2 February 2021

Application by Highways England for an Order Granting Development Consent for the A47 Blofield to North Burlingham project (TR010040)

Procedural Decision following issue of Acceptance decision

DRAWING NUMBER  
HE551490-GTY-EPC-000-DR-LX-30004

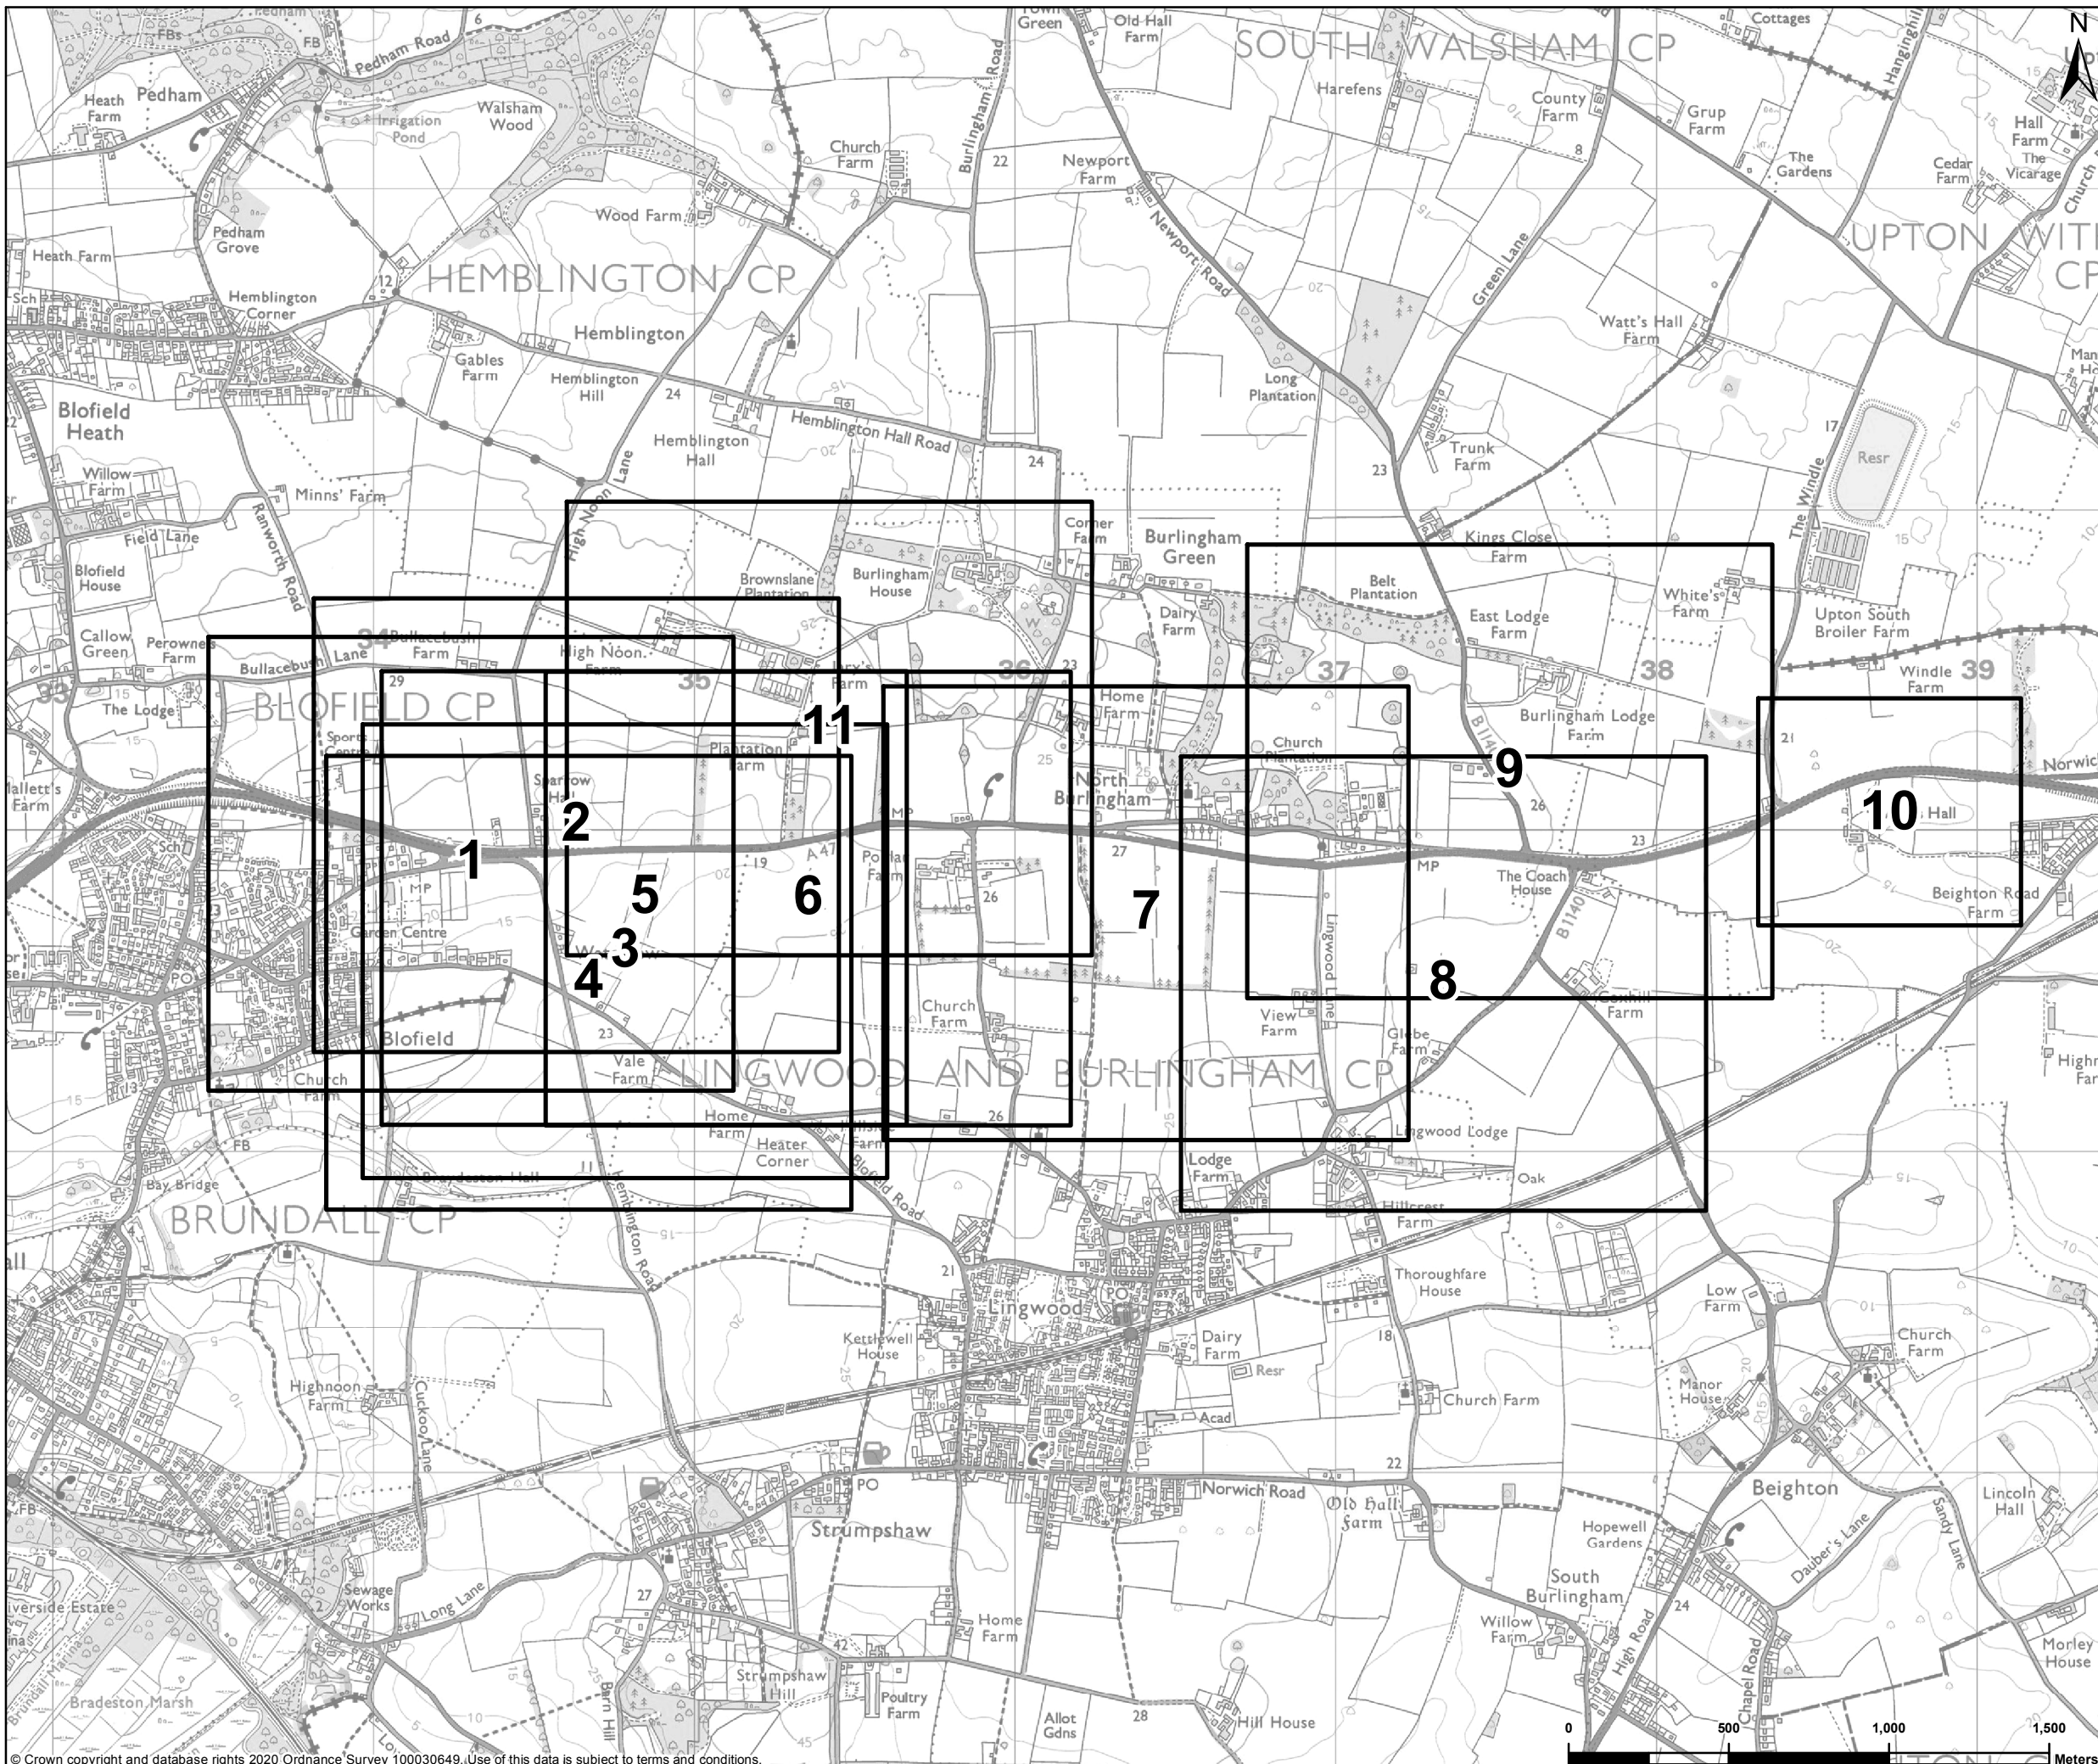
ES Figure 12.3 identifies areas of permanent (pink) and temporary (green) land take in respect of agricultural land holdings. However, whilst these areas are also identified on the Land Plans (Doc 2.2), the Land Plans additionally identify a further category in blue; land to be used temporarily and rights to be acquired permanently. The Applicant should consider whether this category should also be identified on ES Figure 12.3, and if so, amend it accordingly.

Annex A. Constraints maps

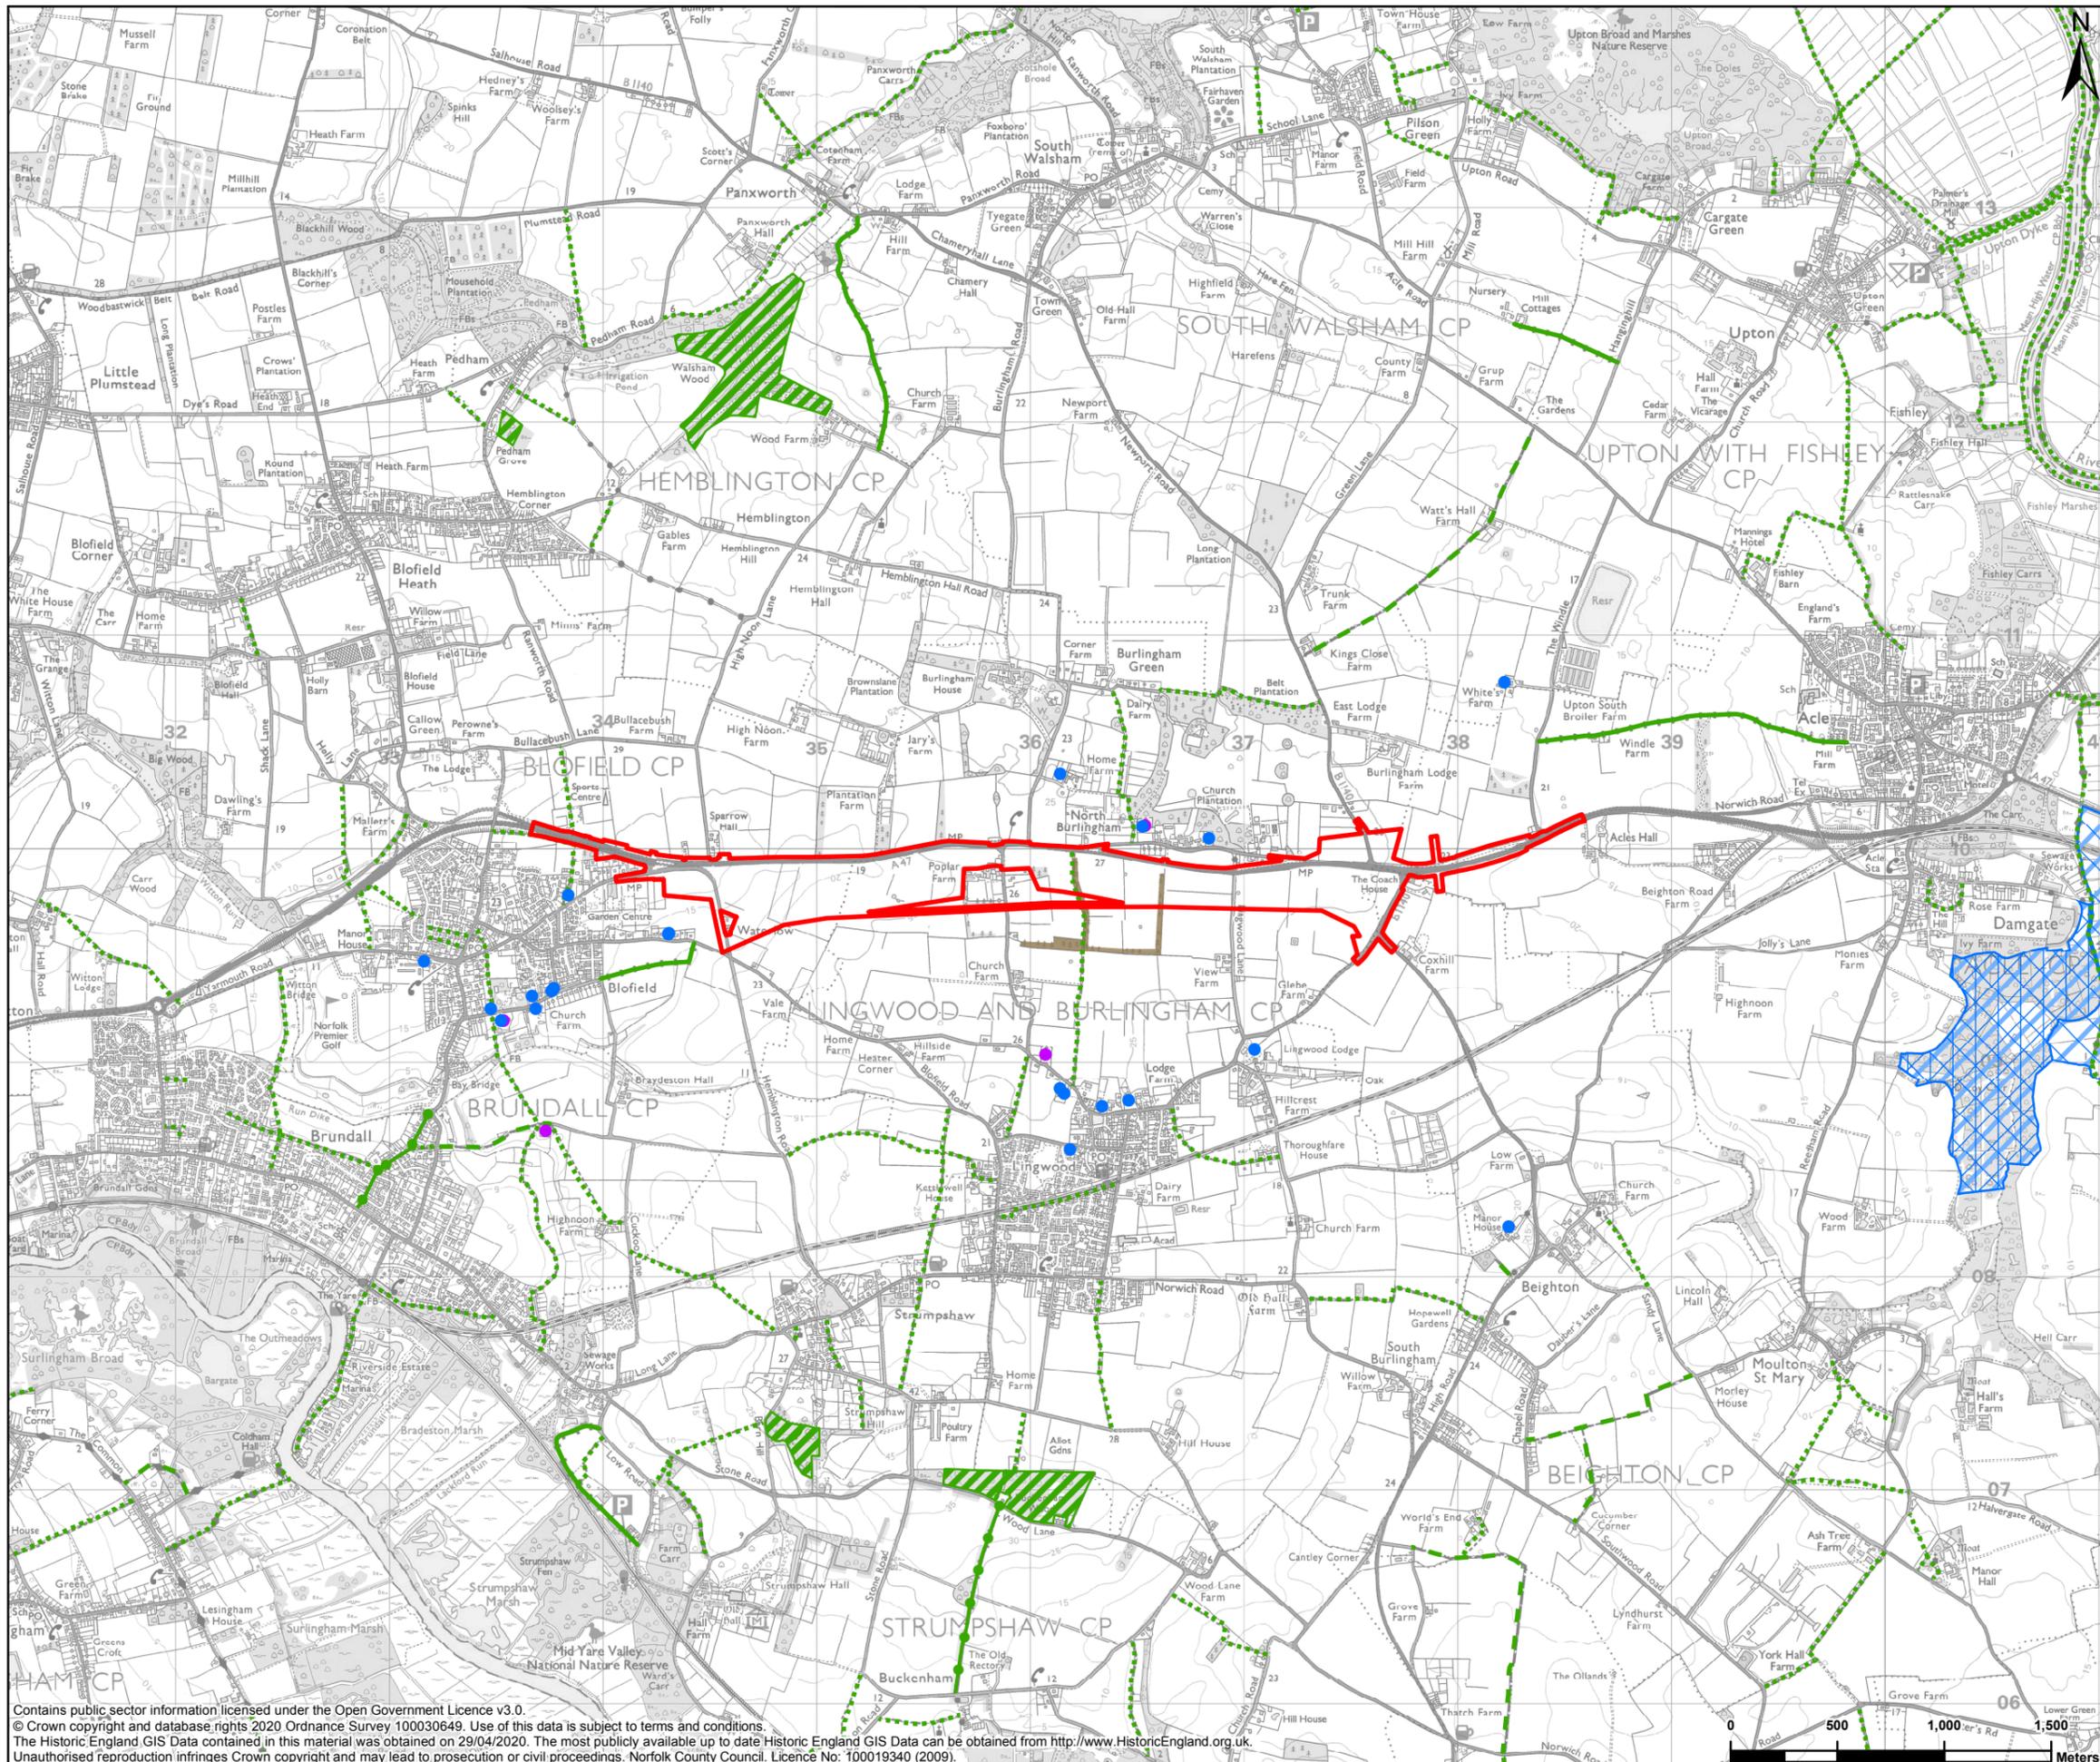
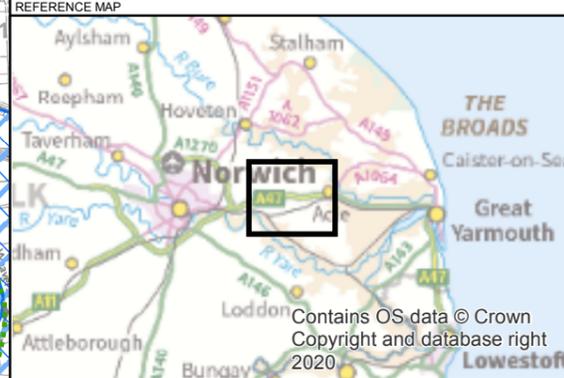
- Whether REAC W7 has inadvertently been omitted, and if so, to amend the REAC accordingly
- Whether there are meant to be two REAC G9 references, and if not, to amend the REAC accordingly
- Whether Annex A: Environmental Management Plan identifies all designated sites, and if not, to amend it accordingly.
